From: [Gibson, Gerry](#)
To: [A30 Chiverton to Carland Cross](#)
Cc: [DEVENNY Alan](#); [Paton, Emma](#); [Walker, Lowri](#); [Armstrong, Angus](#); [Hamilton, David](#); [Howarth, Craig](#); [Inness, Colin](#); [Mill, Stephanie](#)
Subject: A30 Chiverton to Carland Cross Upgrade (PINS Ref TR010026) - SPR comments on documents submitted by the Applicant at Deadline 4
Date: 01 May 2019 17:03:26

Please find below comments on behalf of ScottishPower Renewables (SPR) in relation to documents submitted by the Applicant at Deadline 4 in respect of the A30 Chiverton Cross to Carland Cross DCO.

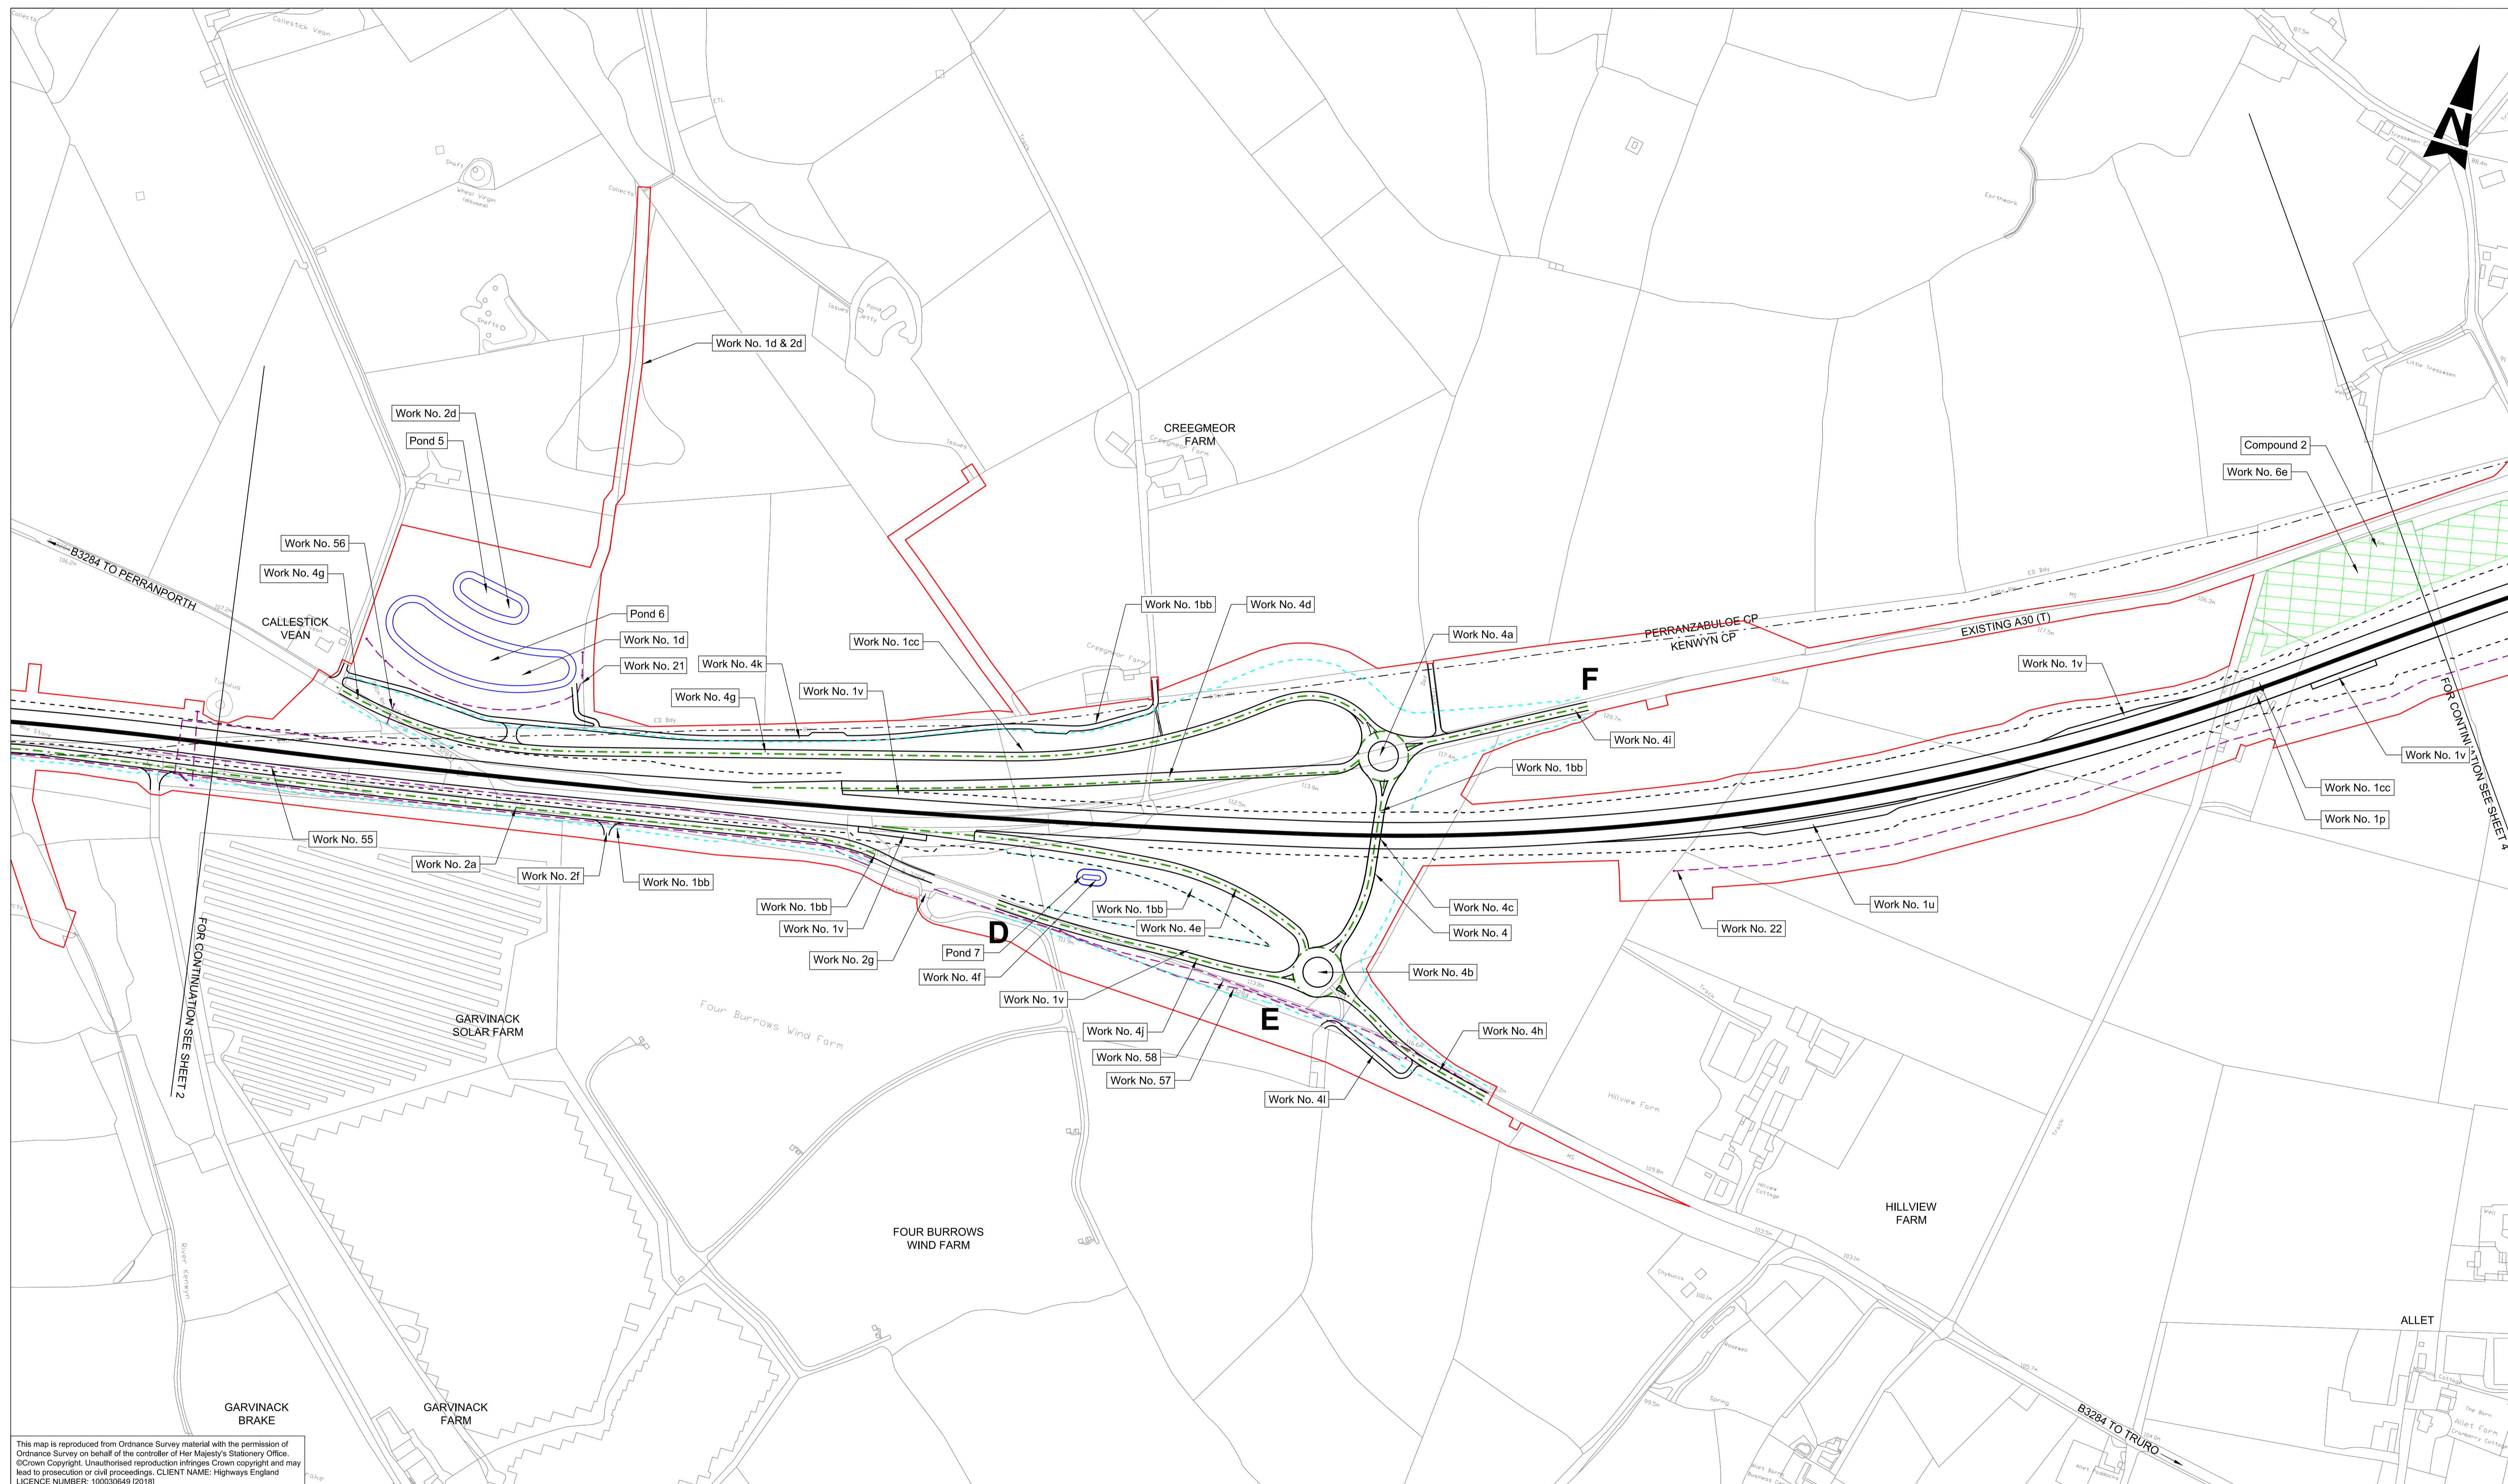
4. SPR notes that Sheet 3 of the updated Works Plans does not show the over-run area across the northern roundabout of the new Chybuca junction as agreed between the Applicant and SPR and SPR would request that this is shown on Sheet 3 of the Works Plans.

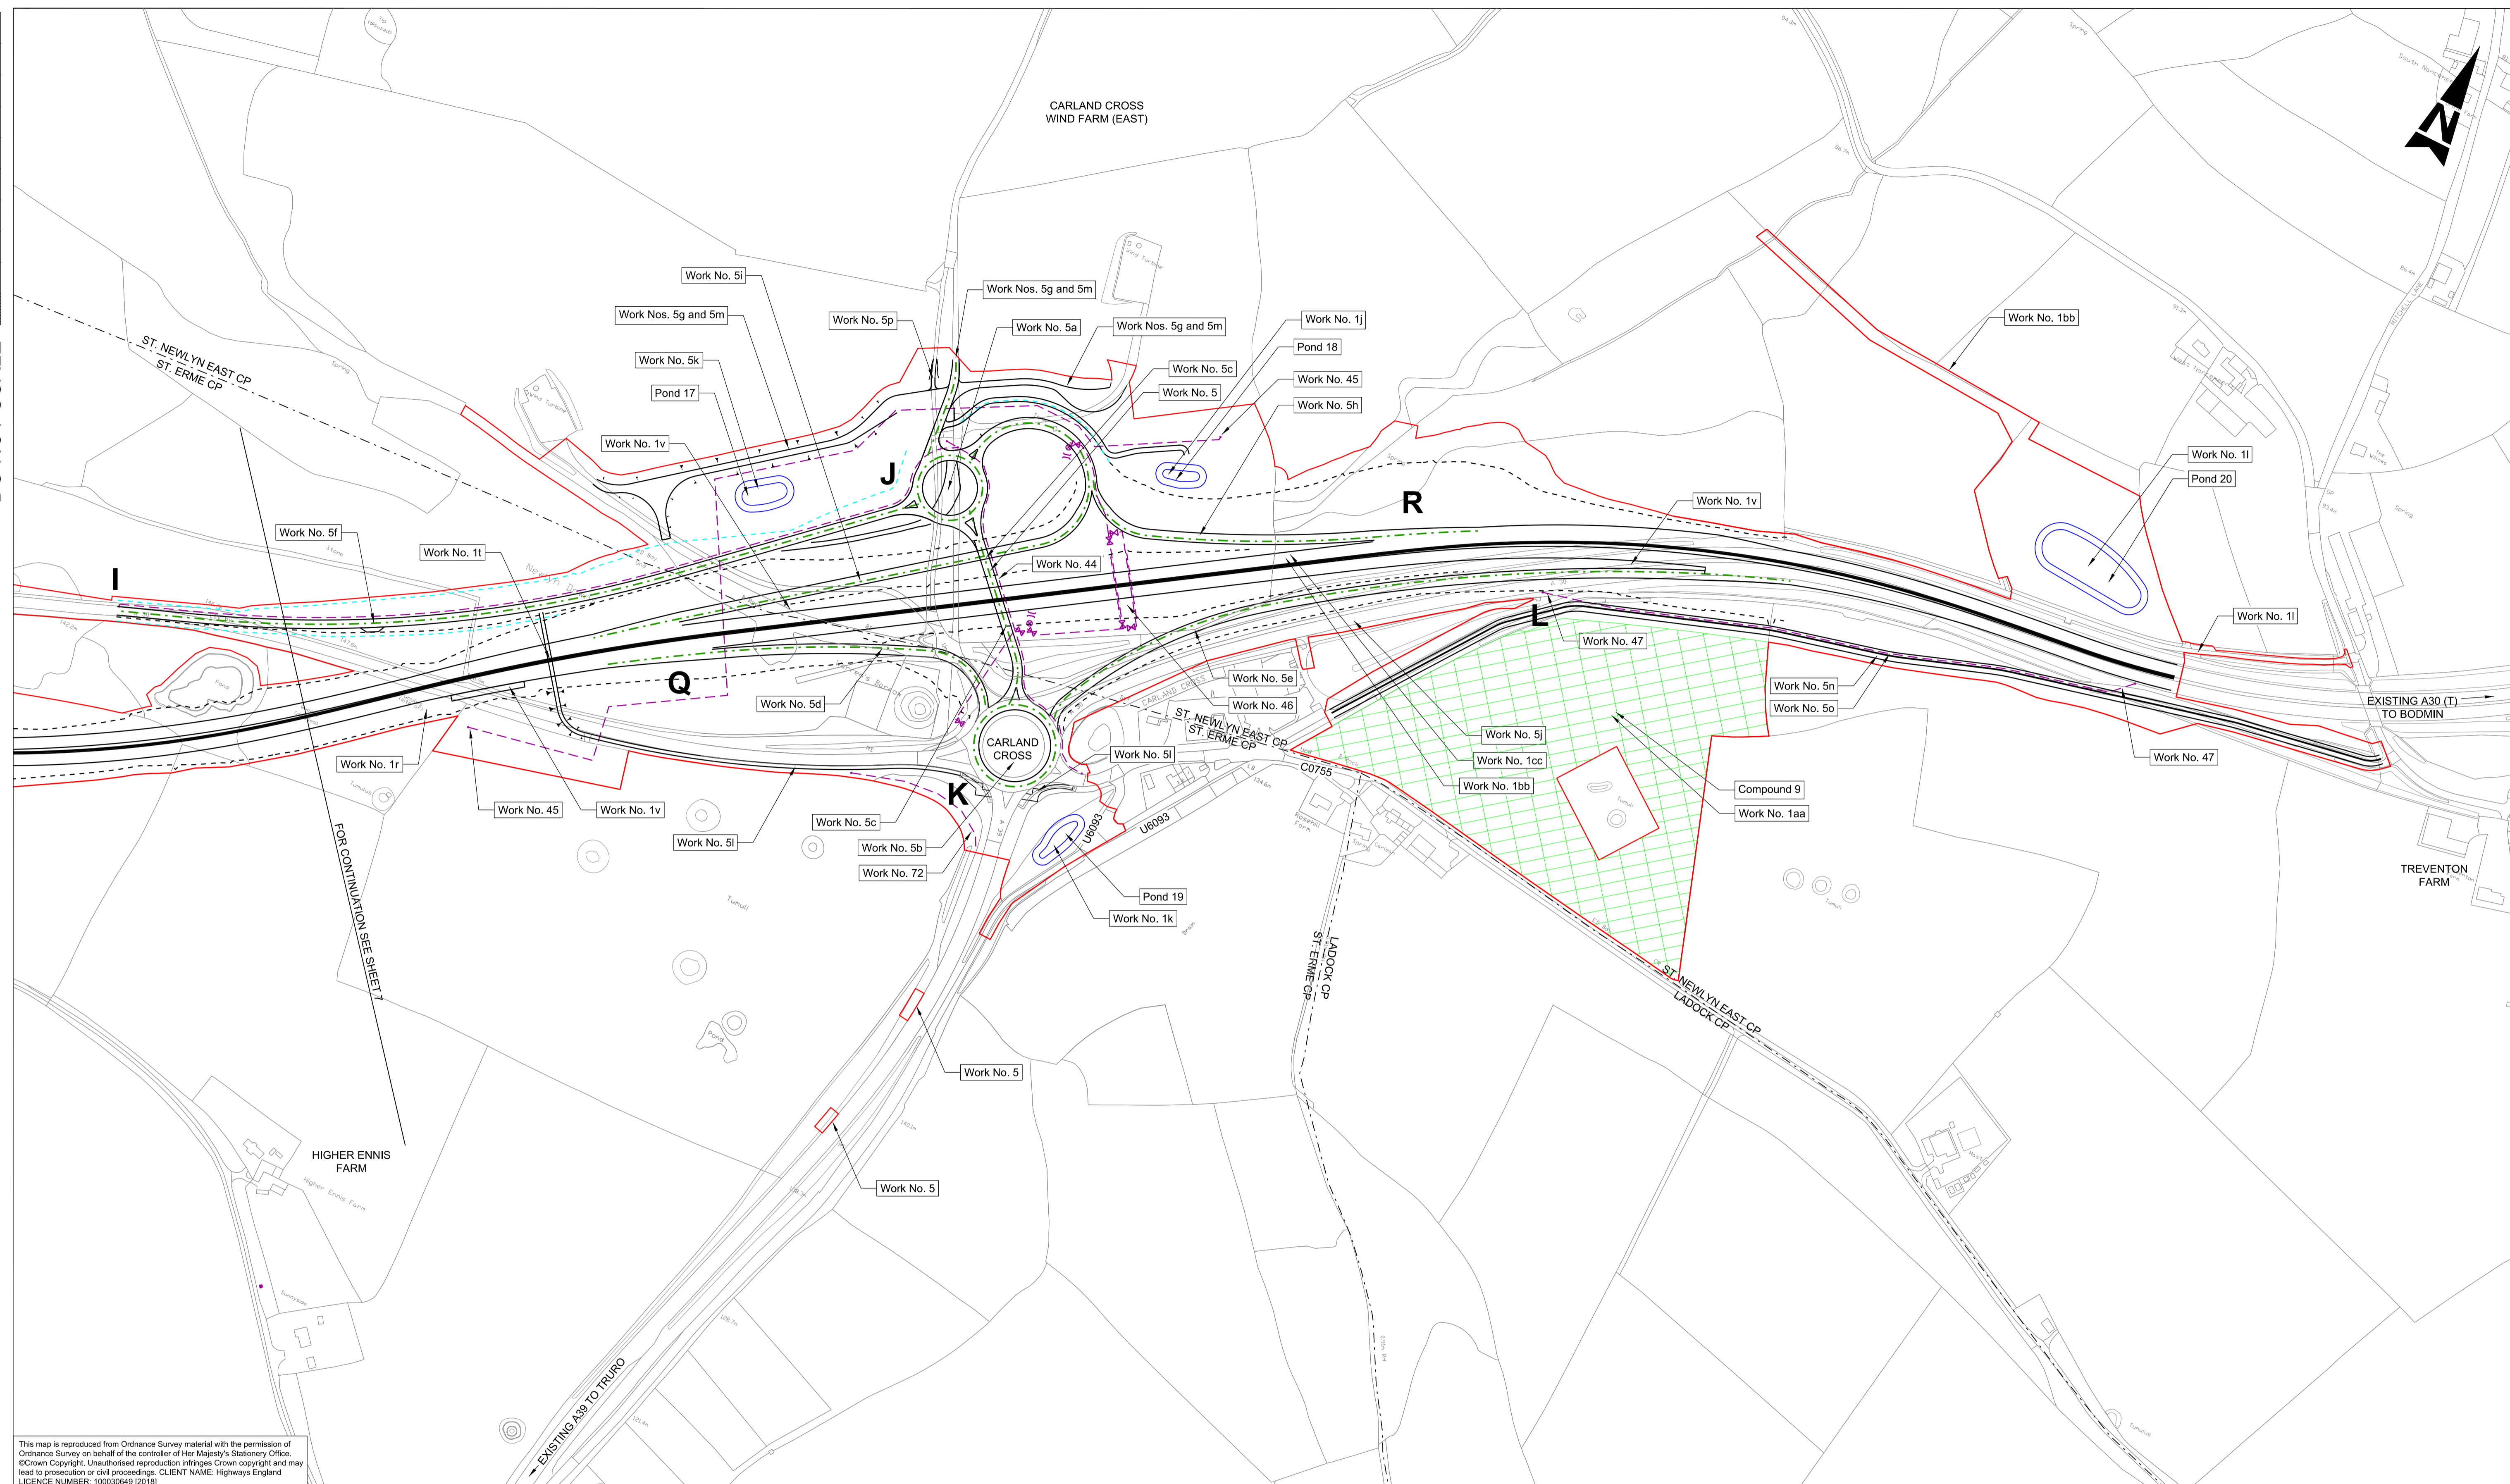
1. SPR welcomes the updates made to Sheet 8 of the Works Plans (Document reference 2.4(C)) to reflect design changes agreed with SPR. SPR notes that the updated Sheet 8 corrects the tie-in error with the wind farm access road and now shows the roundabout over-run and the lay-by facility with two new labels added for Work No 5(a) and Work No. 5(p).

3. SPR would however request that the labelling on Sheet 8 of the Works Plans for Work No. 5(a) or alternatively the description of Work No. 5(a) itself within the DCO makes it clear that the layby from the existing A30 to the new roundabout forms part of Work No. 5(a).
